REFUSAL OF PLANNING PERMISSION

APPLICATION NO. 2019/1415

Proposal Loose boxes for agricultural purposes.
At Land at Thurlstone Road, Penistone, Sheffield S36 9EF

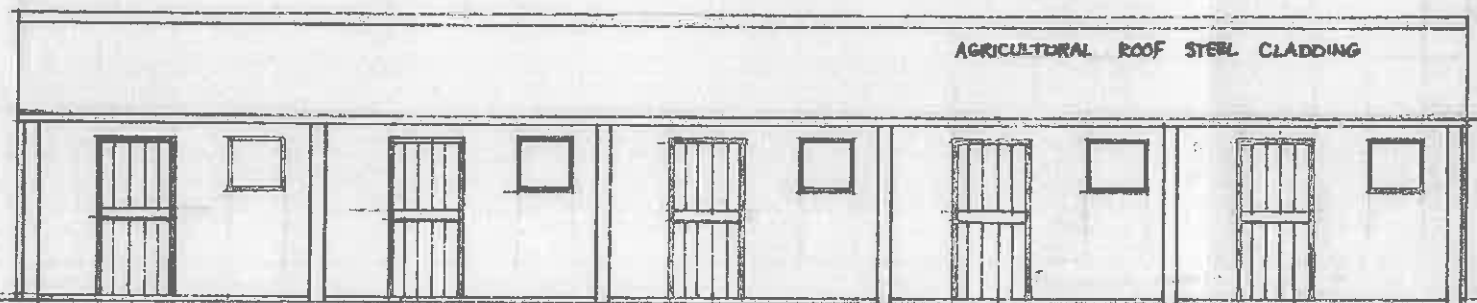
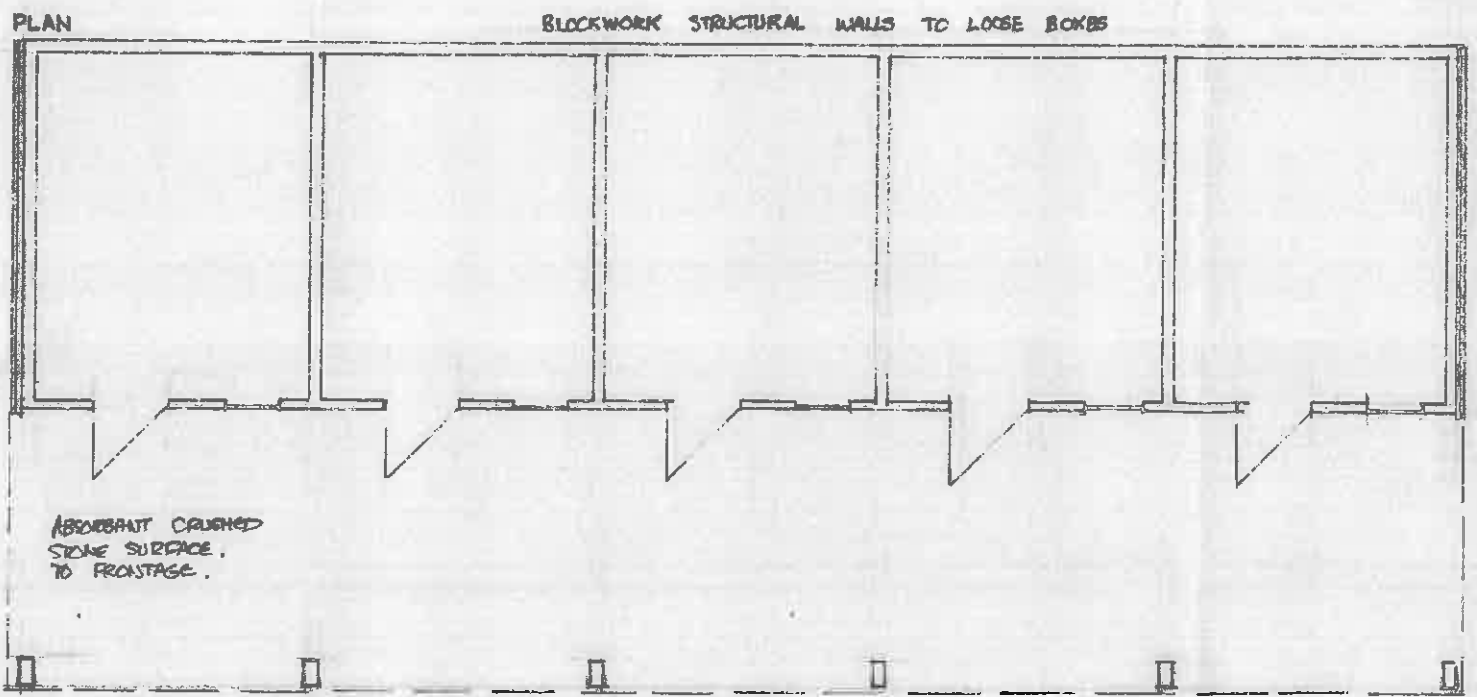
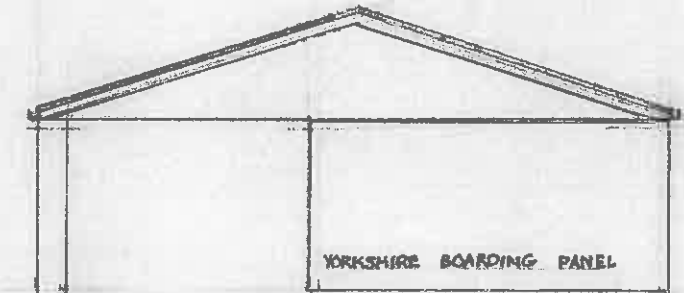
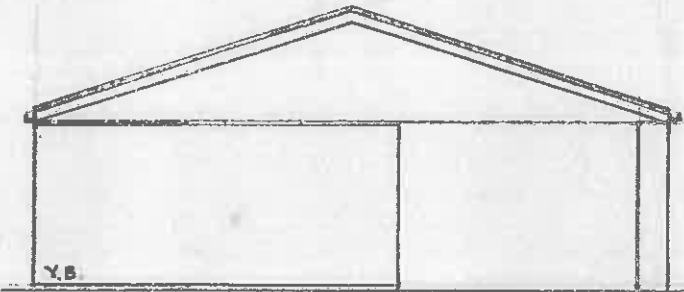
3 In the opinion of the Local Planning Authority, the proposed building would be constructed of a substantial construction, constructed entirely of blockwork and clad in timber, with a 'stable' appearance which is not a typical for modern agricultural buildings. The building is of a significant size, scale and design and would appear as a prominent structure from Thurlstone Road and would be unacceptable in terms of visual amenity and design contrary to policy D1 of the Local Plan.
